Harnett County, North Carolina

Telecommunications Site Review Tower Foundation Upgrade Application

**RE: Harnett County - BCOM 1810-0006
SBA Towers – “368-594”**

**FOUNDATION
MODIFICATION DETAILS**

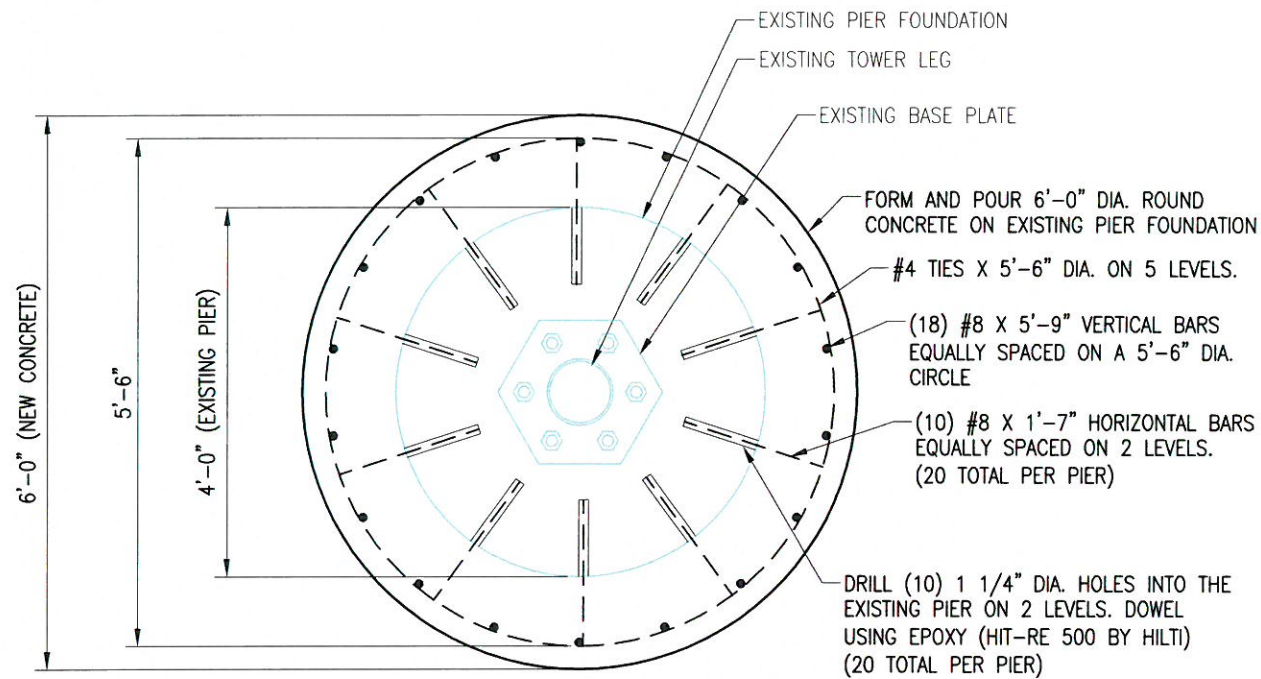
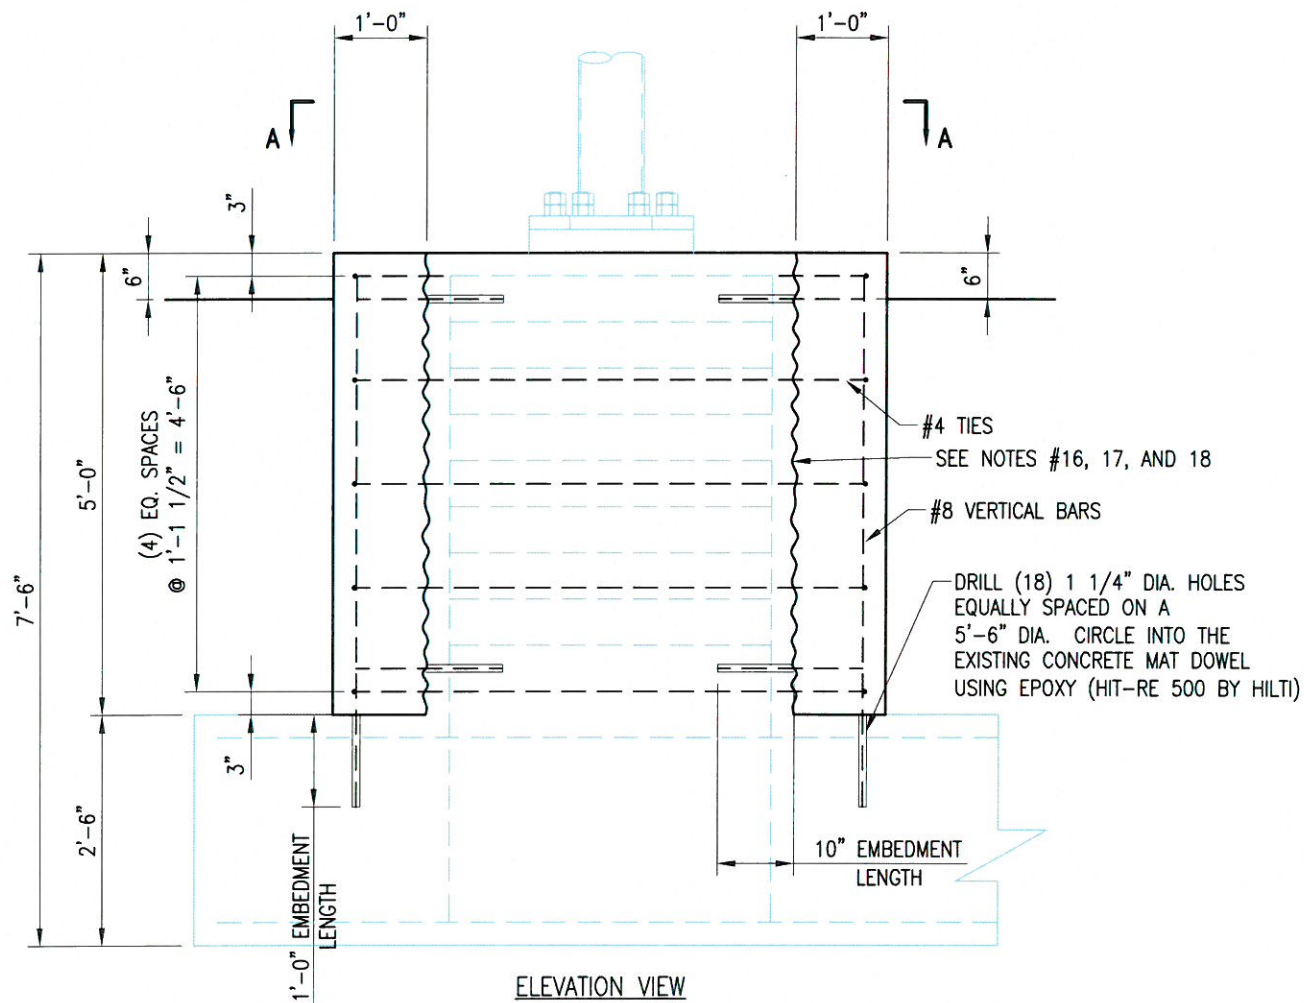
The tower stress rating was and remains satisfactory at 103.8% out of an allowable 105%, but for some reason it was found the foundation was overstressed:

<u>Foundations</u>			
	Compression (Kips)	Uplift (Kips)	Shear (Kips)
Original Design Reactions	317.1	262.3	31.5
Analysis Reactions	495.2	427.3	49.8
Factored Reactions*	428.0	354.1	42.5
% of Design Reactions	115.7%	120.7%	117.3%

All aspect of the foundation stress exceeded allowed limits of 110%. Following the modifications described in the analysis the new foundation stress rating will be 67% out of a maximum of 110%, see *figure 2*.
